Our Ref: FS0728.LT.001

Grangewood School, Fore Street, Eastcote, Pinner HA5 2JQ

Local Planning Authority Reference: 2145/APP/2022/3543

Thank you for your comments regarding the above planning application. Please see our responses below regarding the proposed drainage condition 9 of your planning application response.

P01	FIRST ISSUE	21.06.23	CRR	LG
Rev:	Description:	Date:	By:	Chkd:

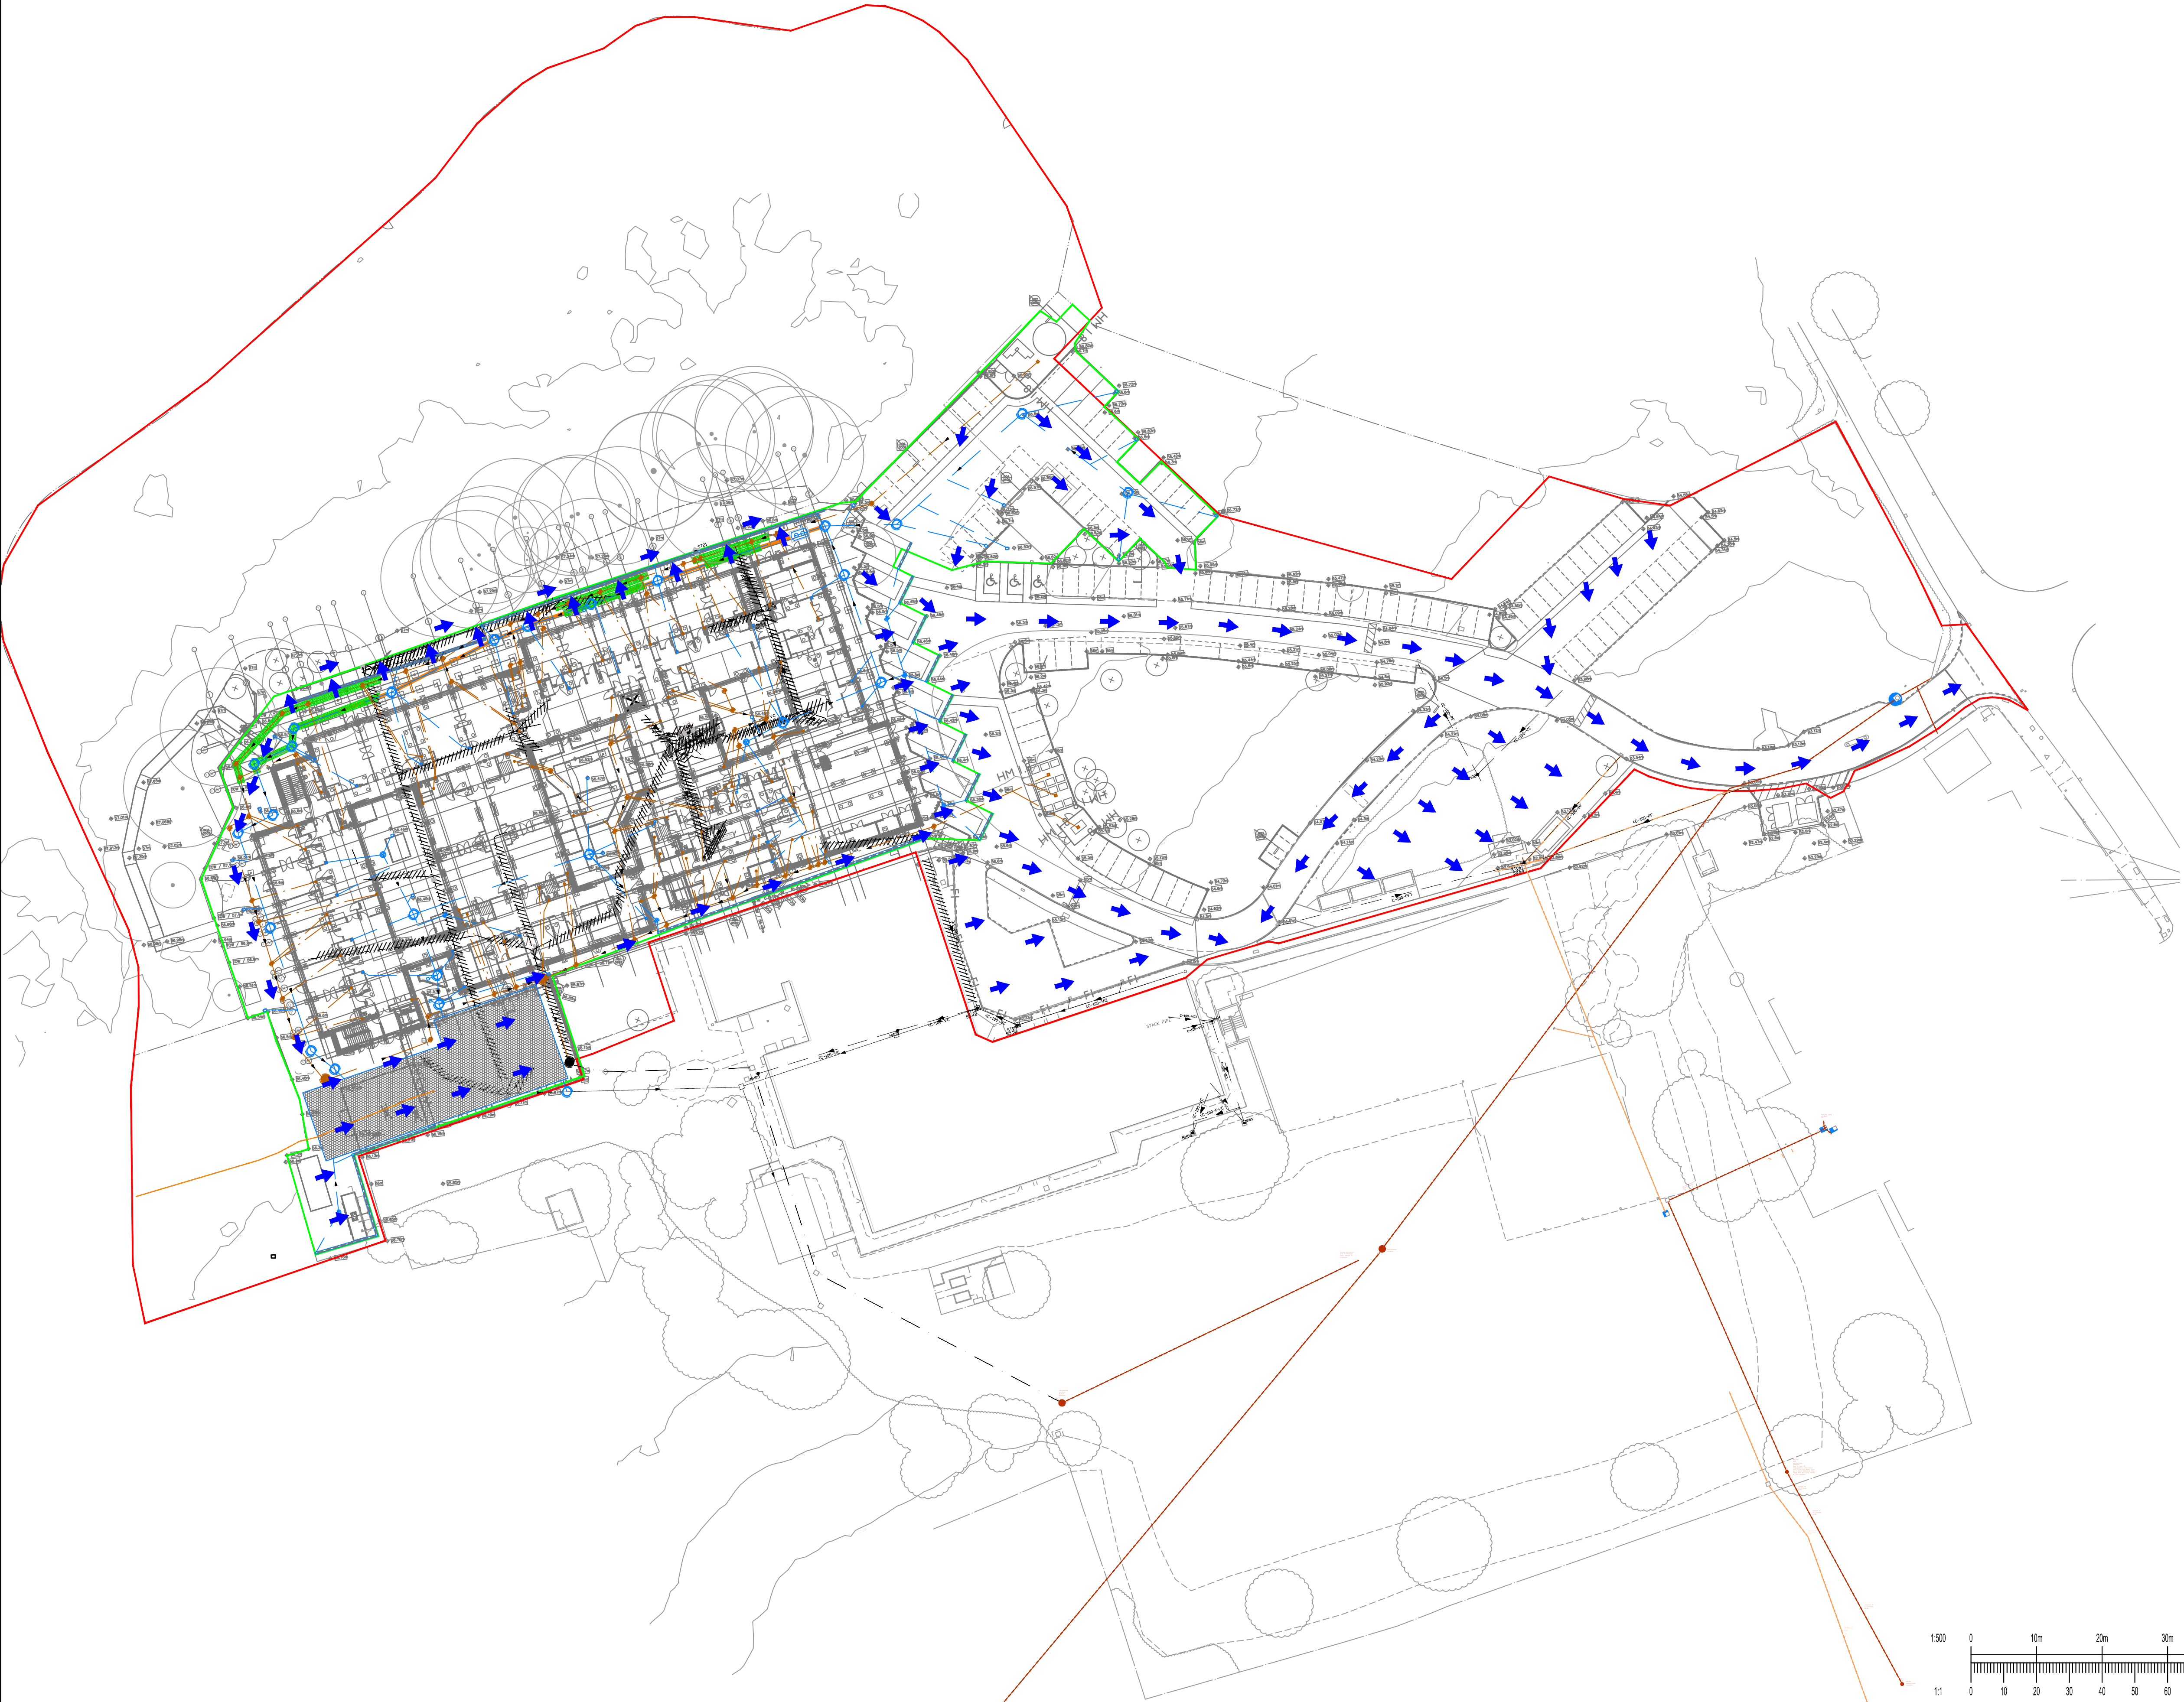
Comment a) vi. *Exceedance routes - provide a plan showing the route surface water will take through the development for rainfall events exceeding the 1 in 100 year event. Where it is intended to store water on the ground surface, the maximum extent of overland flooding should be mapped and include details on flow paths, depths and velocities. Safe access and egress for the site must be demonstrated.*

Please refer to the exceedance plan (ref. FS0728-CUR-XX-XX-DR-C-0504) appended to this letter.
